Fire Marshal Division

Re: PJ's Truck Bodies
1560 George Perry Lee Rd.
Dunn, NC 28334

Application Number FMFW1812-0005

# Pyro Chem U.L. 1254 AUTO SPRAY PAINT BOOTH FIRE SUPPRESSION SYSTEM

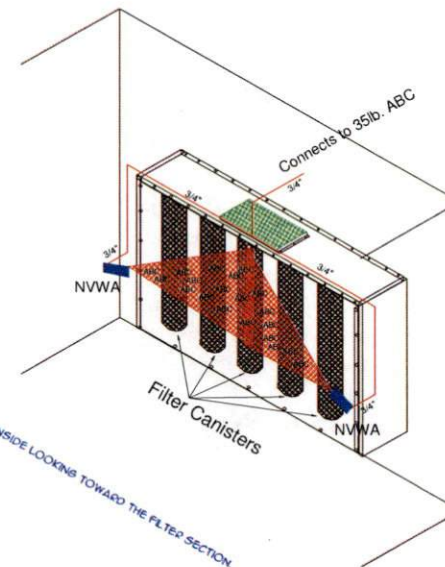
- **904.6 Dry-chemical systems.**
 - Dry-chemical extinguishing systems shall be installed, maintained, periodically inspected and tested in accordance with the North Carolina Fire Prevention Code, NFPA 17 and their listing.

- **1504.7.1 Ventilation Interlocks**
 - With a total flooding system, the ventilation system for the paint booth is required to shut down before the system operates.
 - Spaying operations **CANNOT** be conducted without the operation of the ventilation system. An interlock must be provided between the ventilation system and spraying operation.

- Hazard specification for consistency with design hazard.
- Type, location and spacing of automatic- and manual- initiating devices.
 - Size, placement and position of nozzles or discharge orifices.
 - Location and identification of audible and visible alarm devices.
 - Identification of devices with proper designations.
 - Operating instructions.
